STATE OF WASHINGTON  
DEPARTMENT OF ECOLOGY

January 28, 2021

Thank you for allowing the Department of Ecology (Ecology) the opportunity to review and comment on the variance application VA-20-00013.

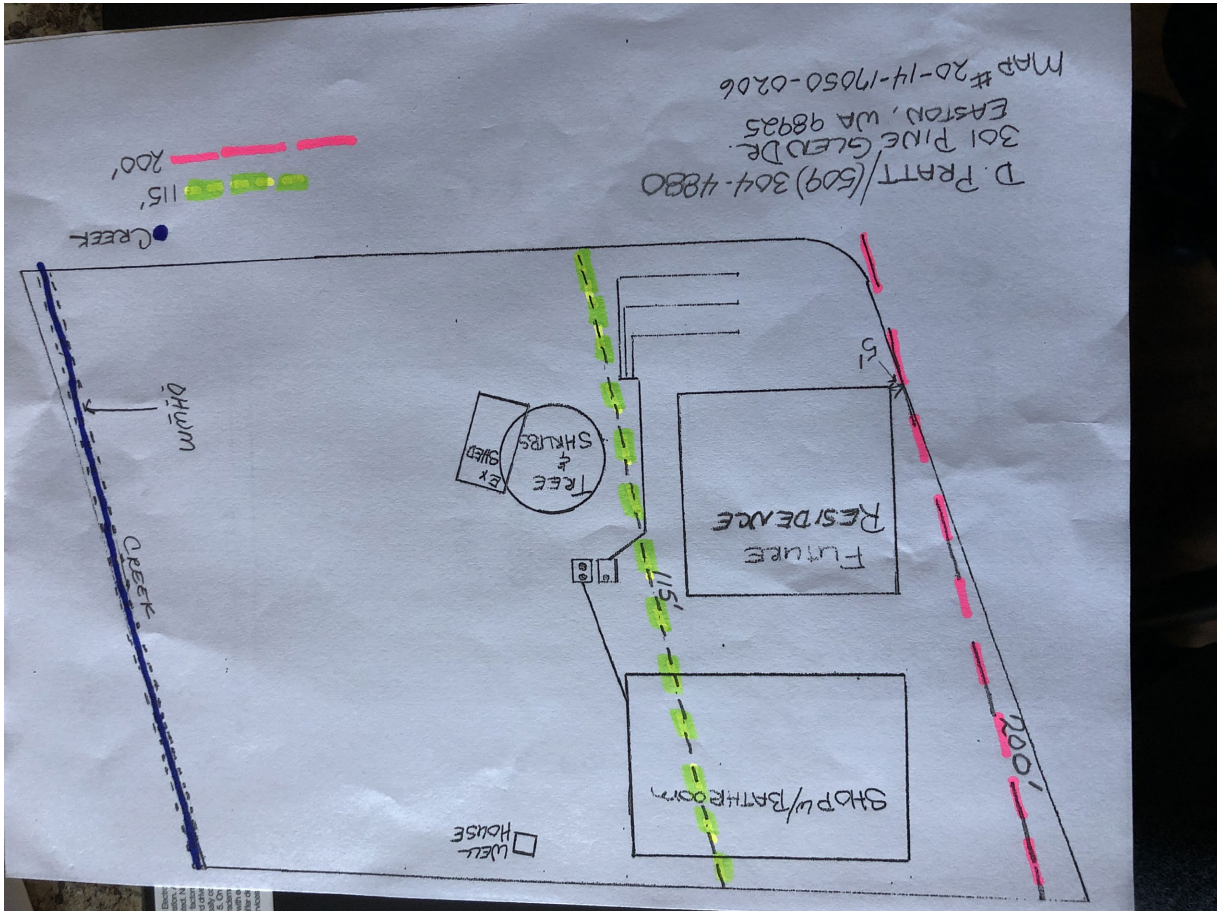
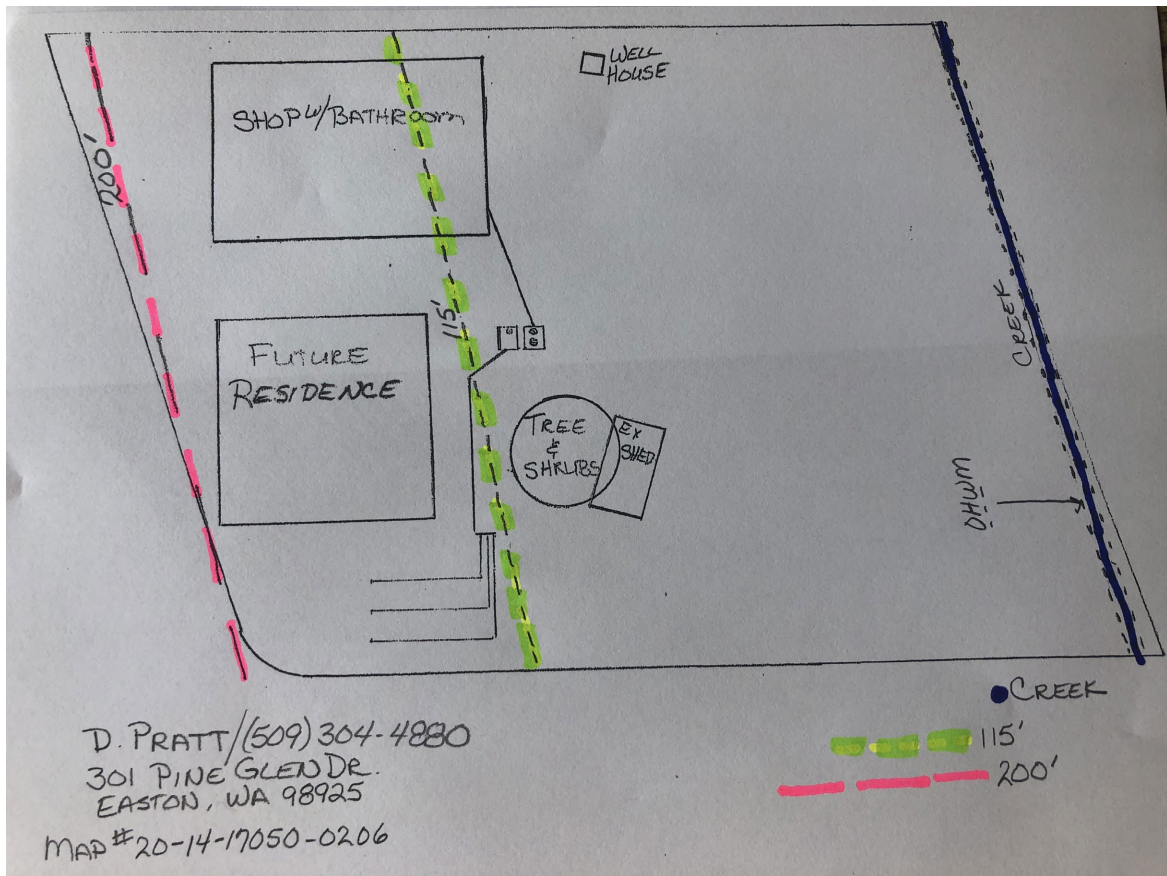
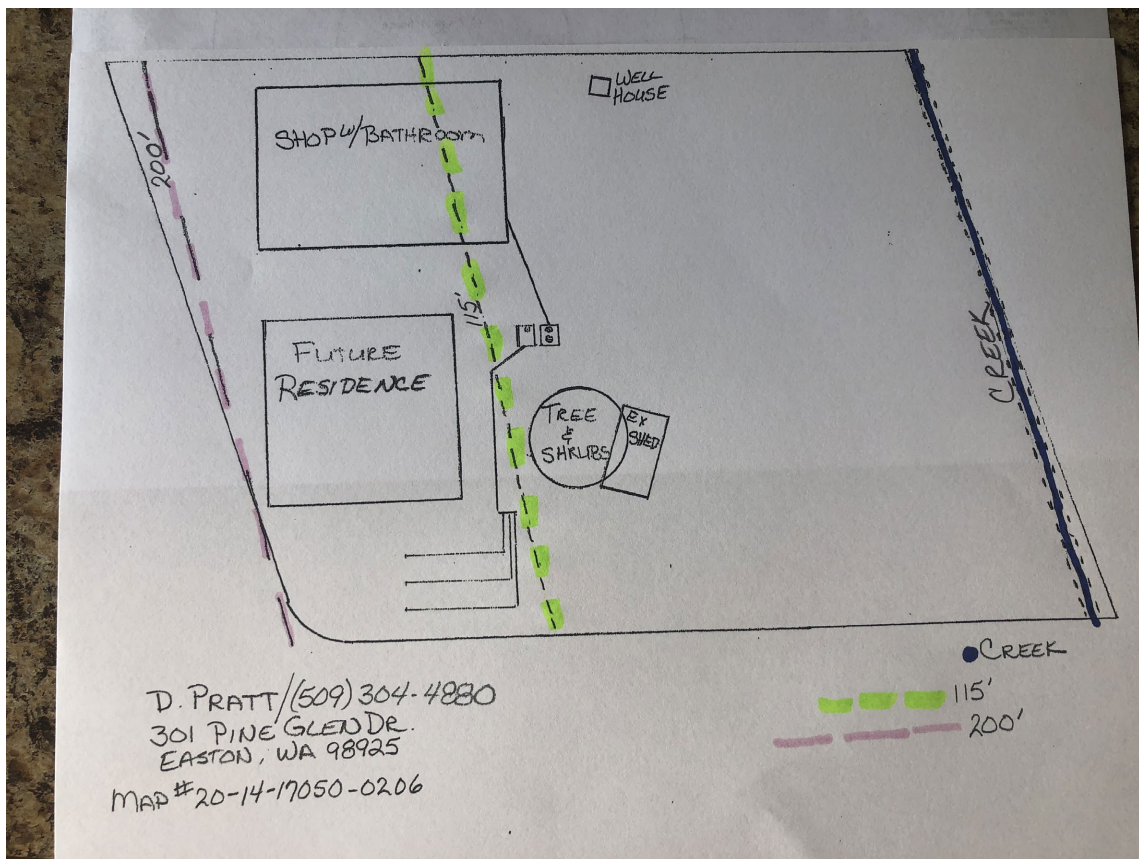
We request that the submitted site plan be updated with the appropriate shoreline buffer and setback information, and the project be reviewed to shoreline standards.
